12/28/2023

I am writing to express extreme concerns regarding the proposed meat processing facility by 3 BR Custom Cuts located at 3200 Wilson Creek Rd in Ellensburg, Washington.

Drawing file: CU-23-00001 3 BR Custom Cuts / CU-23-00001 3 BR Custom Cuts Site Plan.pdf

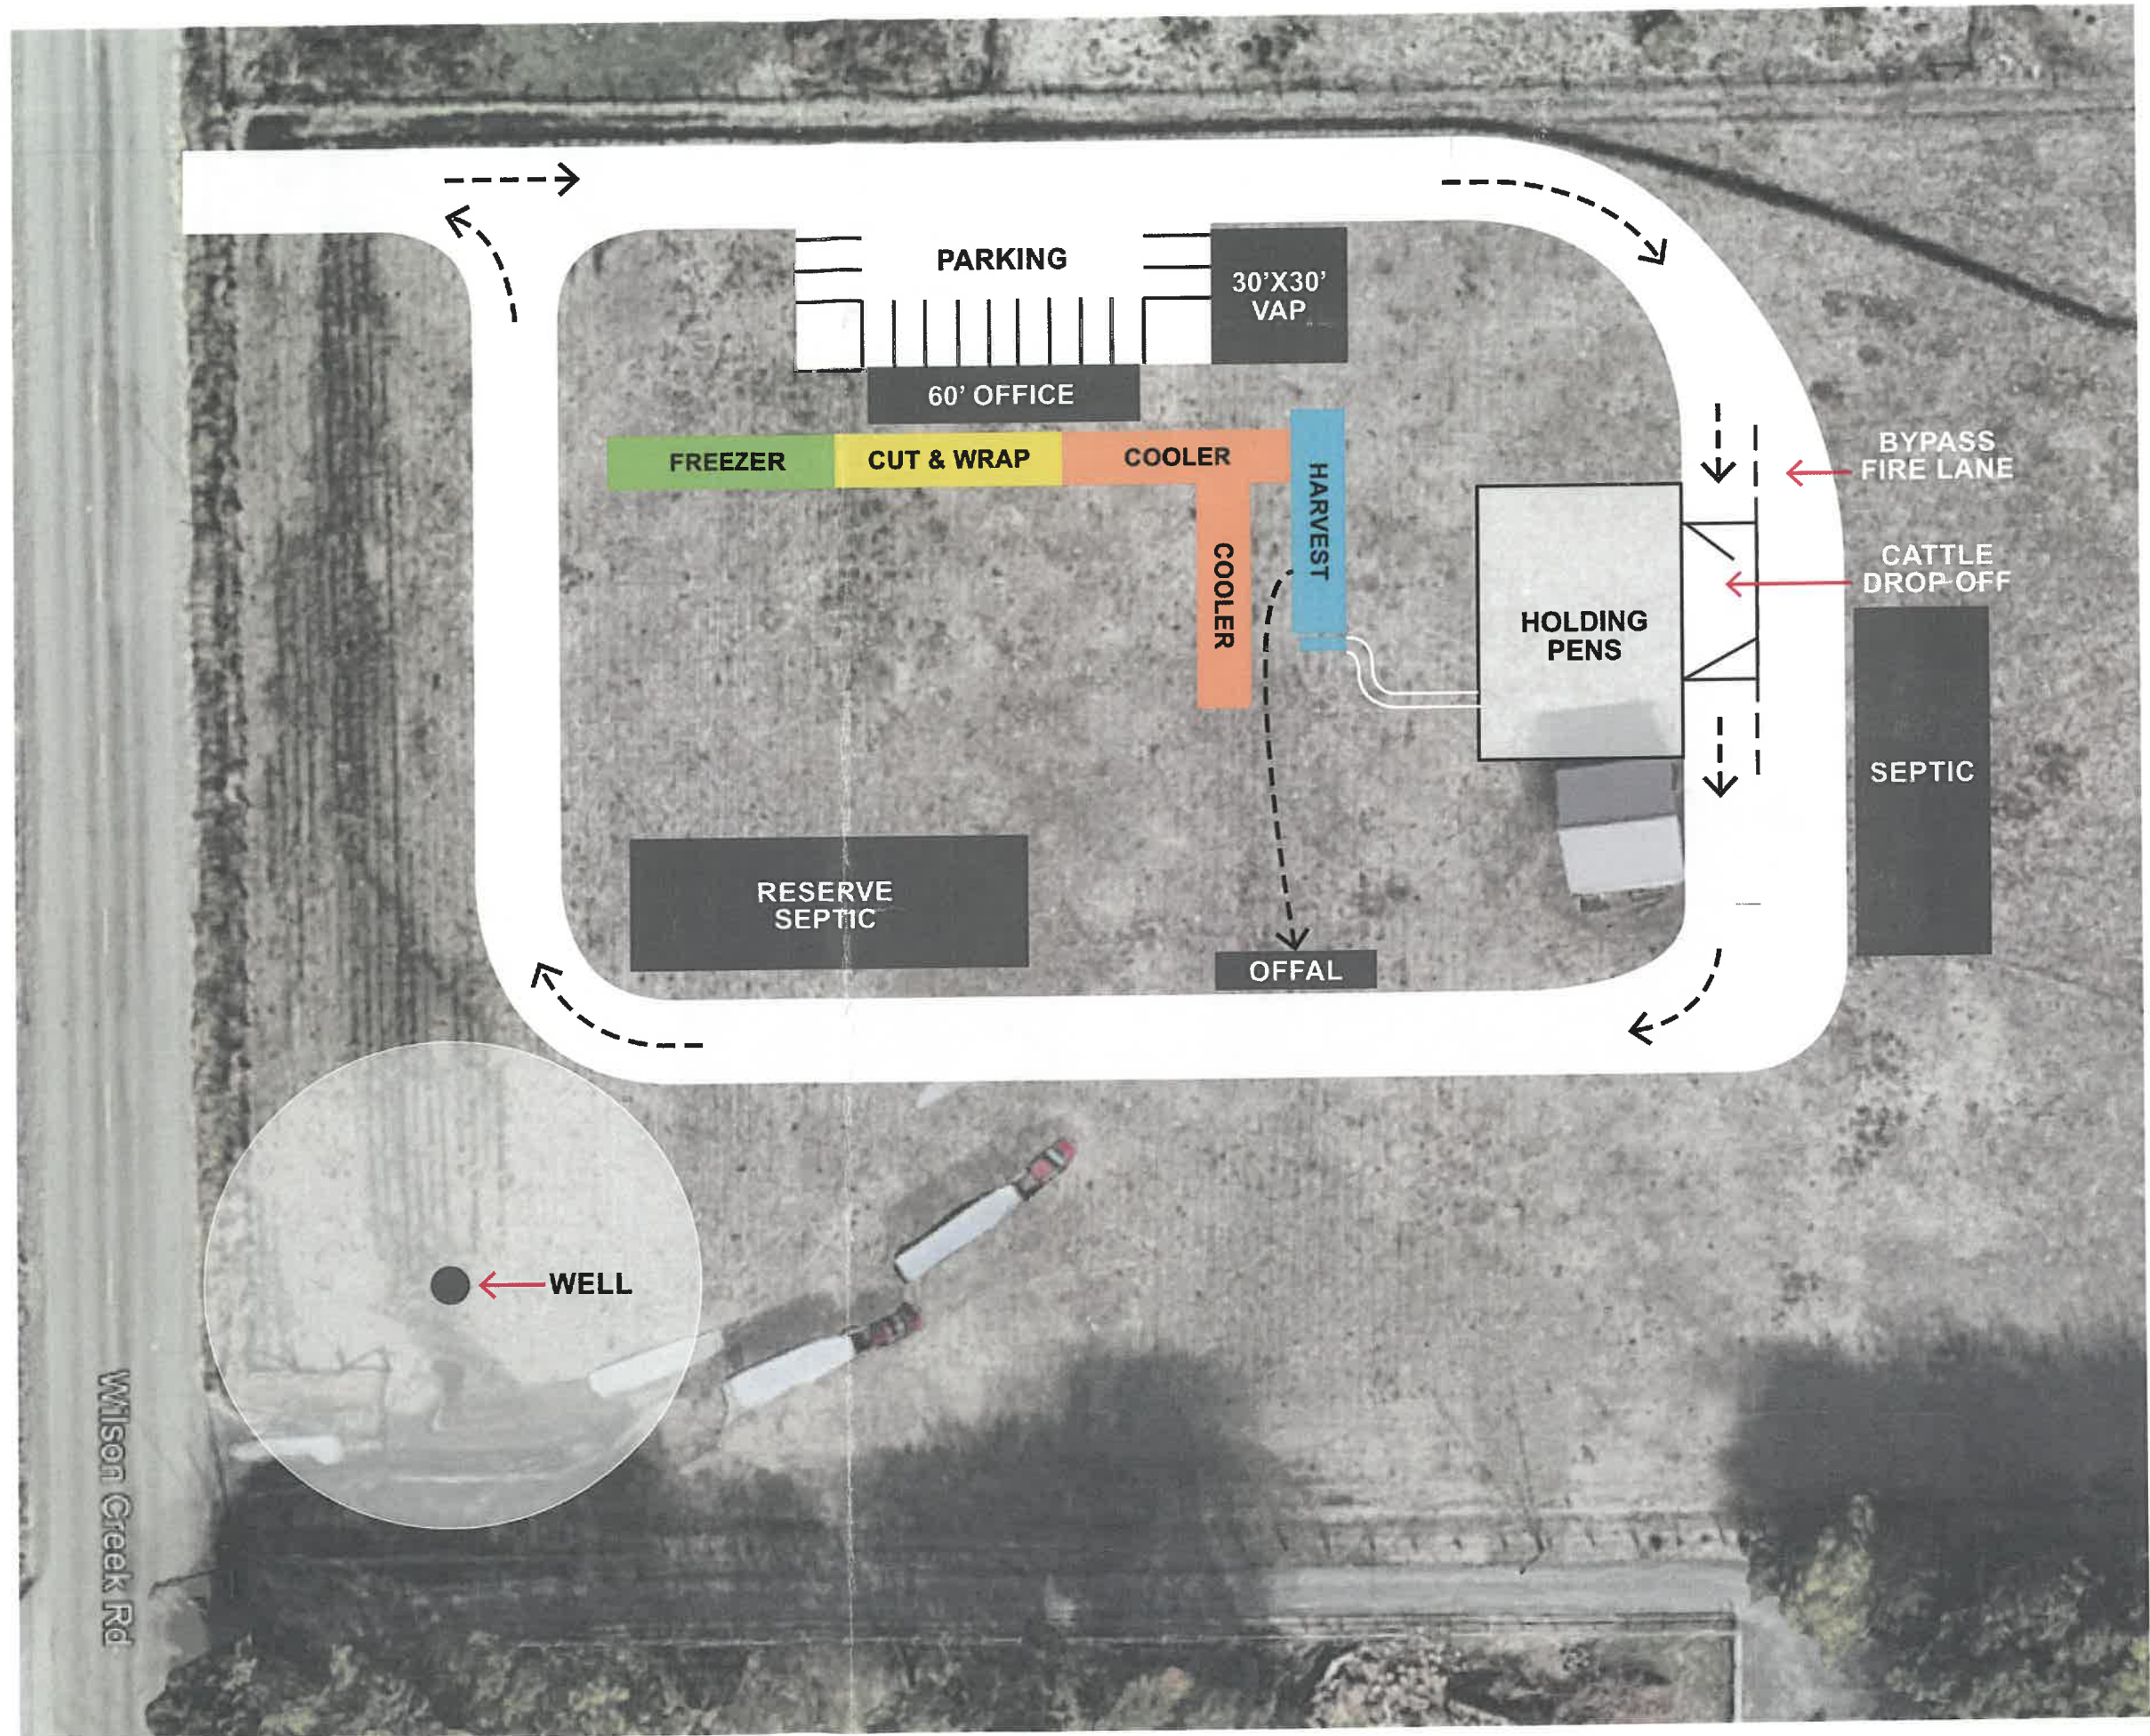
- The plans for cattle, pigs, sheep, and goats processed at the same facility creates many questions. Will there need to be a holding pen for each type of animal? A separate day for each breed? The space indicated on the drawings for holding pens is a very small area for 30 animals to be held.

**3BR CUSTOM CUTS  
PROCESSING PLANT**

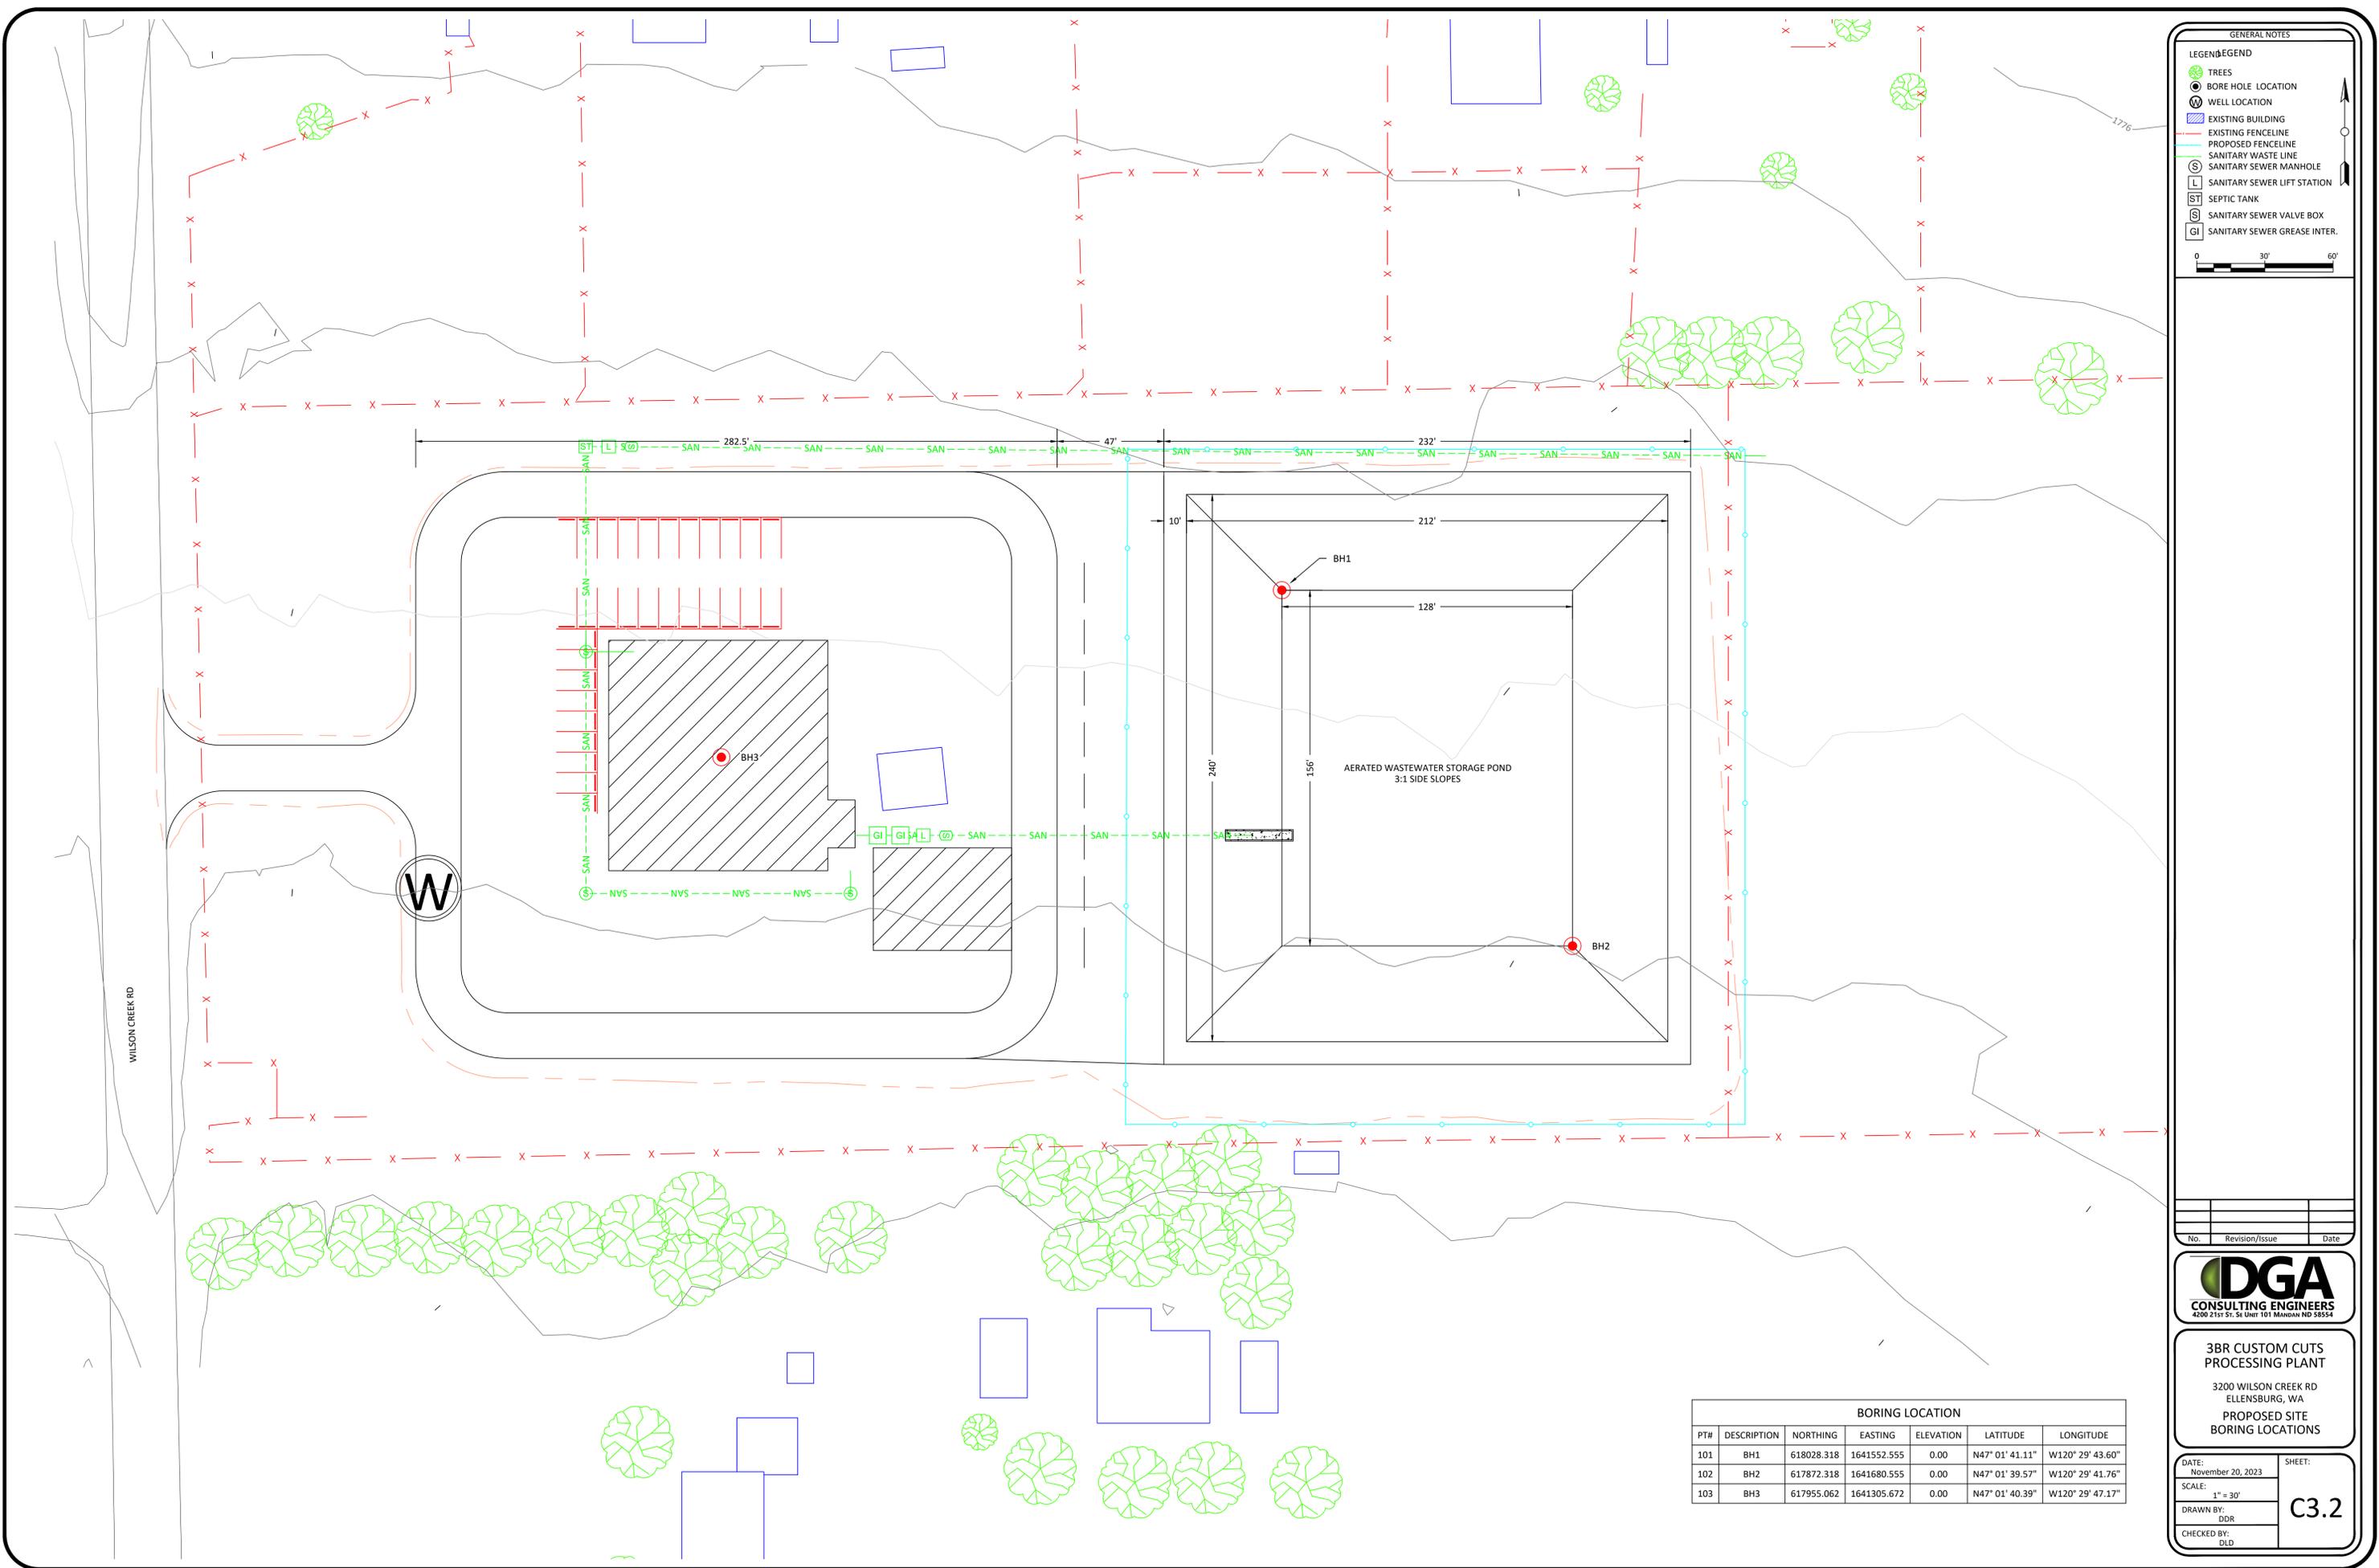
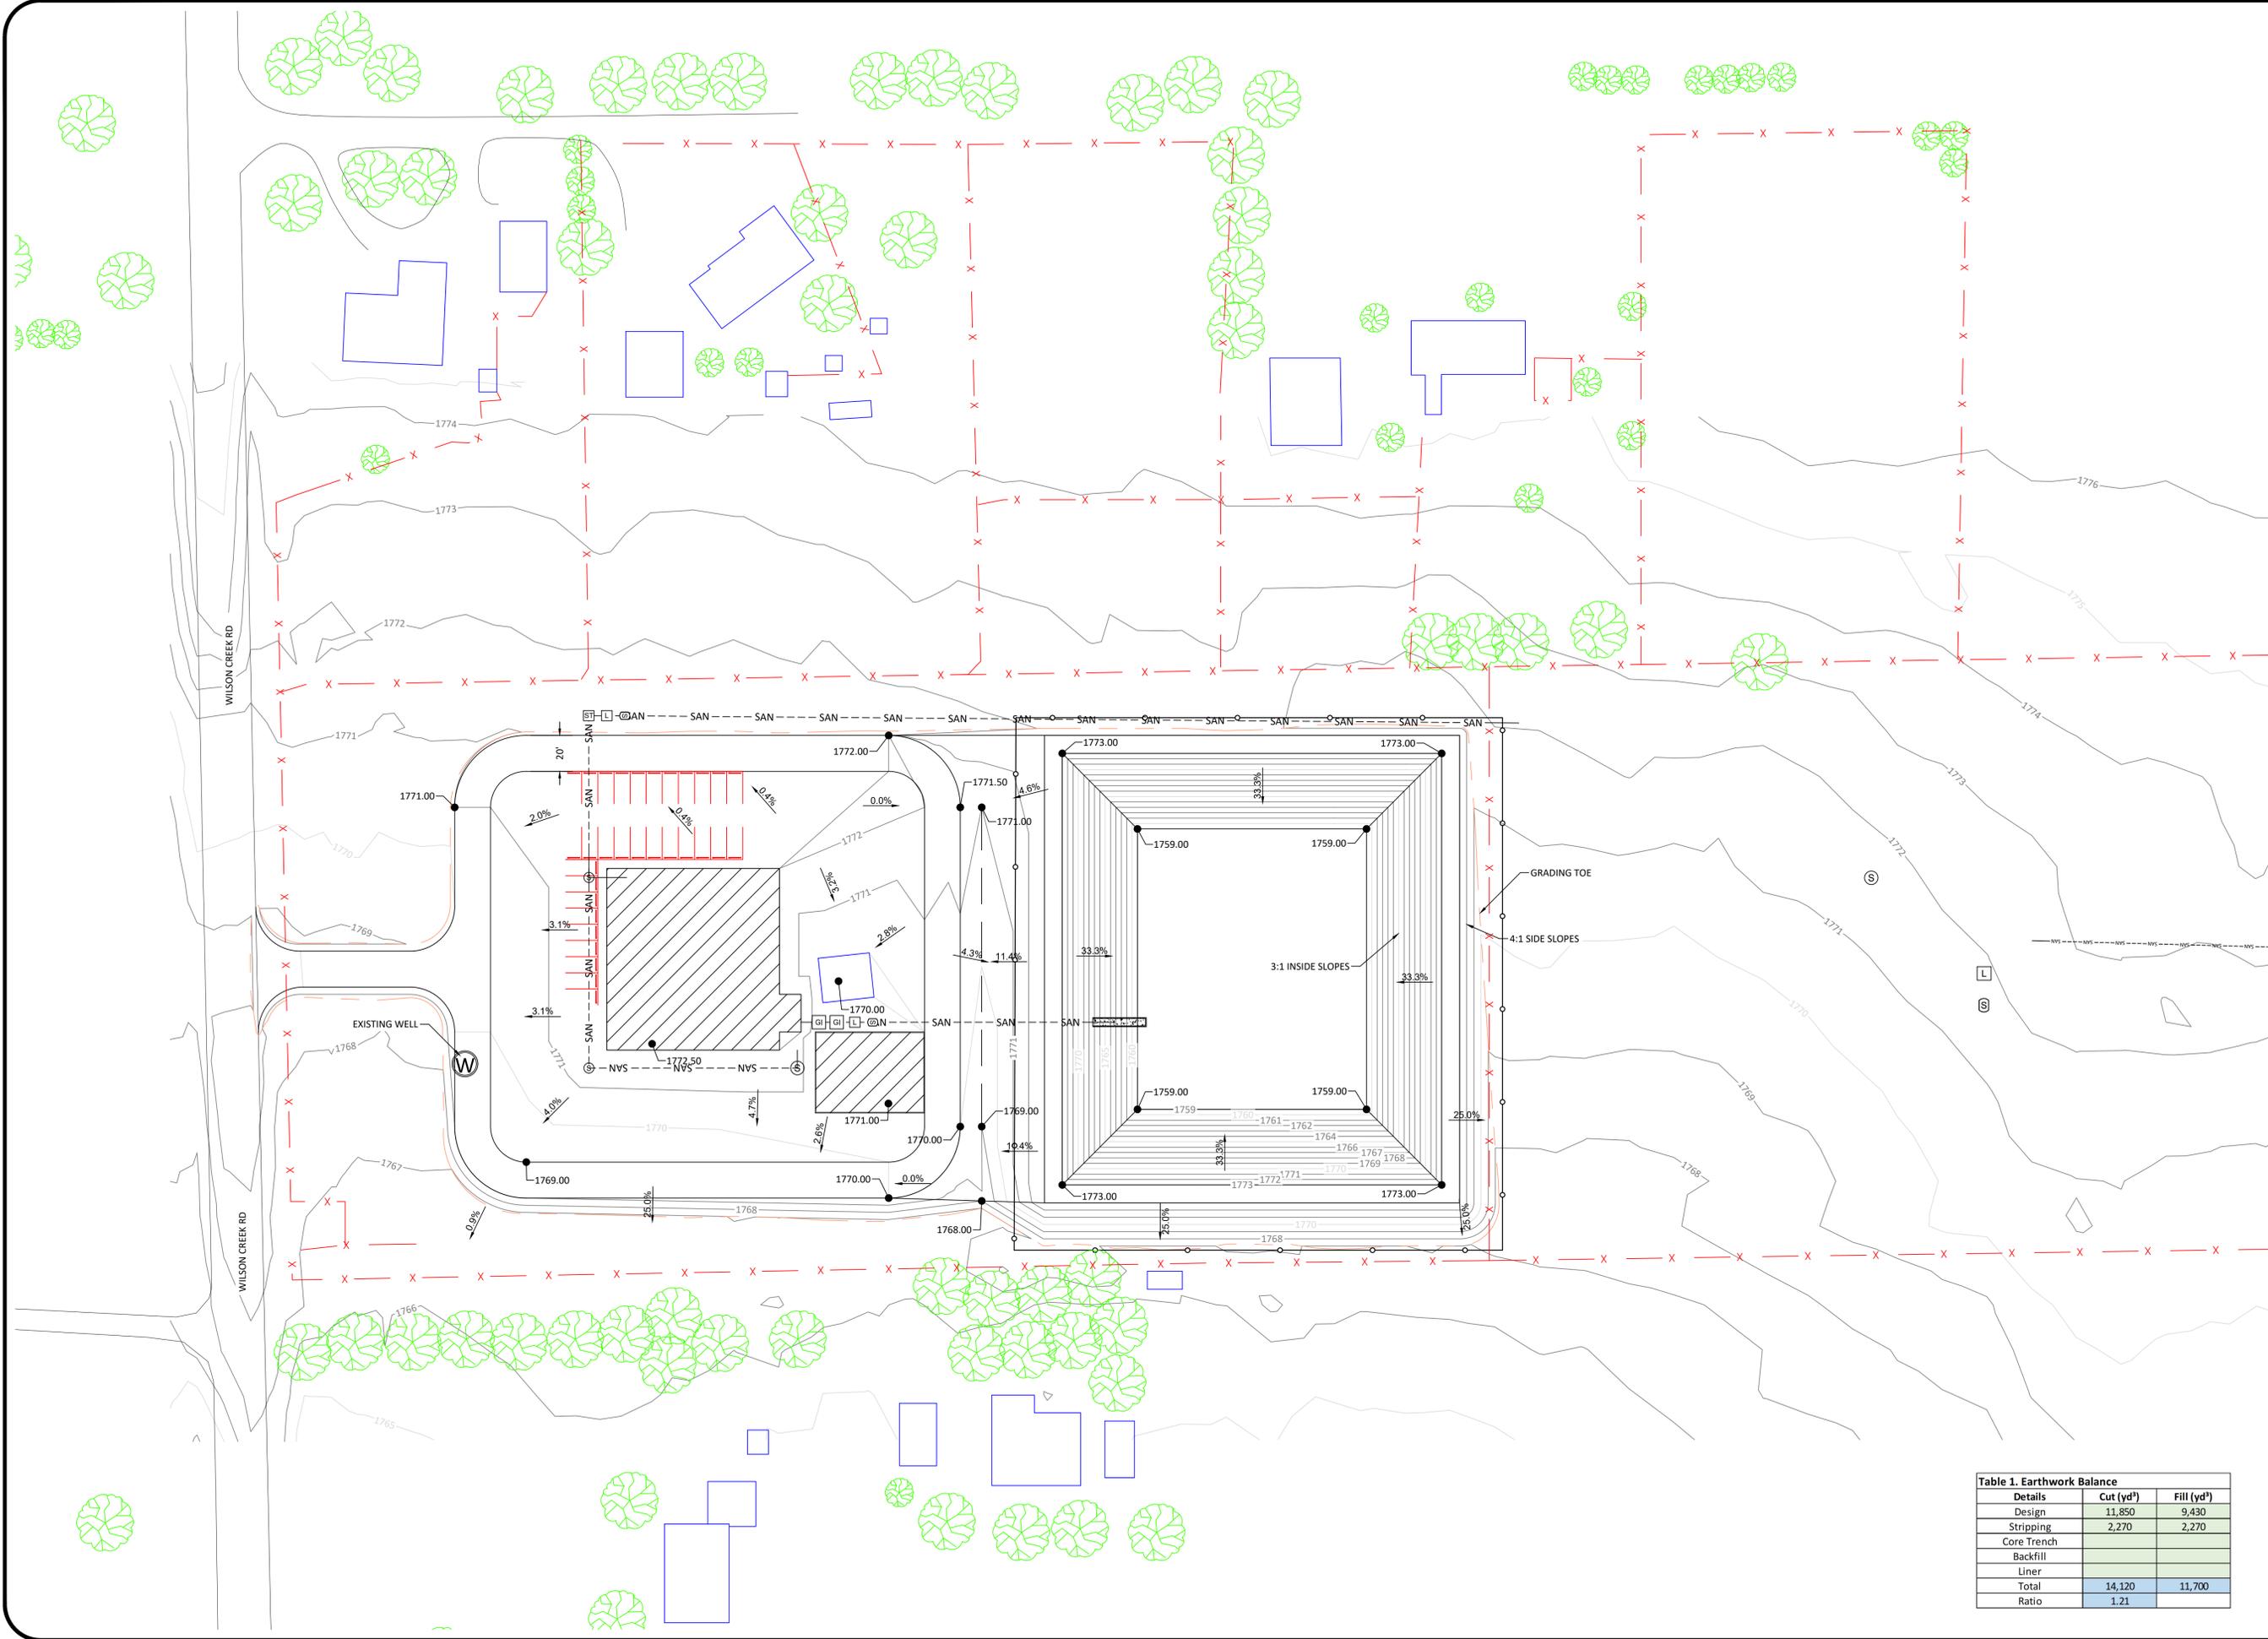
- The water table in this area is very high. When digging down standing water will accumulate. How will that effect the function of this system? Where will that water go so this lagoon can be lined?

- The location of this is right on the property line that is approximately 60 feet from my home.
- The noise from the pumps needed to maintain this waste and circulate the slurry will be continuous.

- It is stated that there will be leak detection in this “double lined” lagoon. But what happens when there is a leak? What kind of lining will be utilized? How many years is this lining approved for? Will this lining be changed on a regular basis? Should the requirement for this be
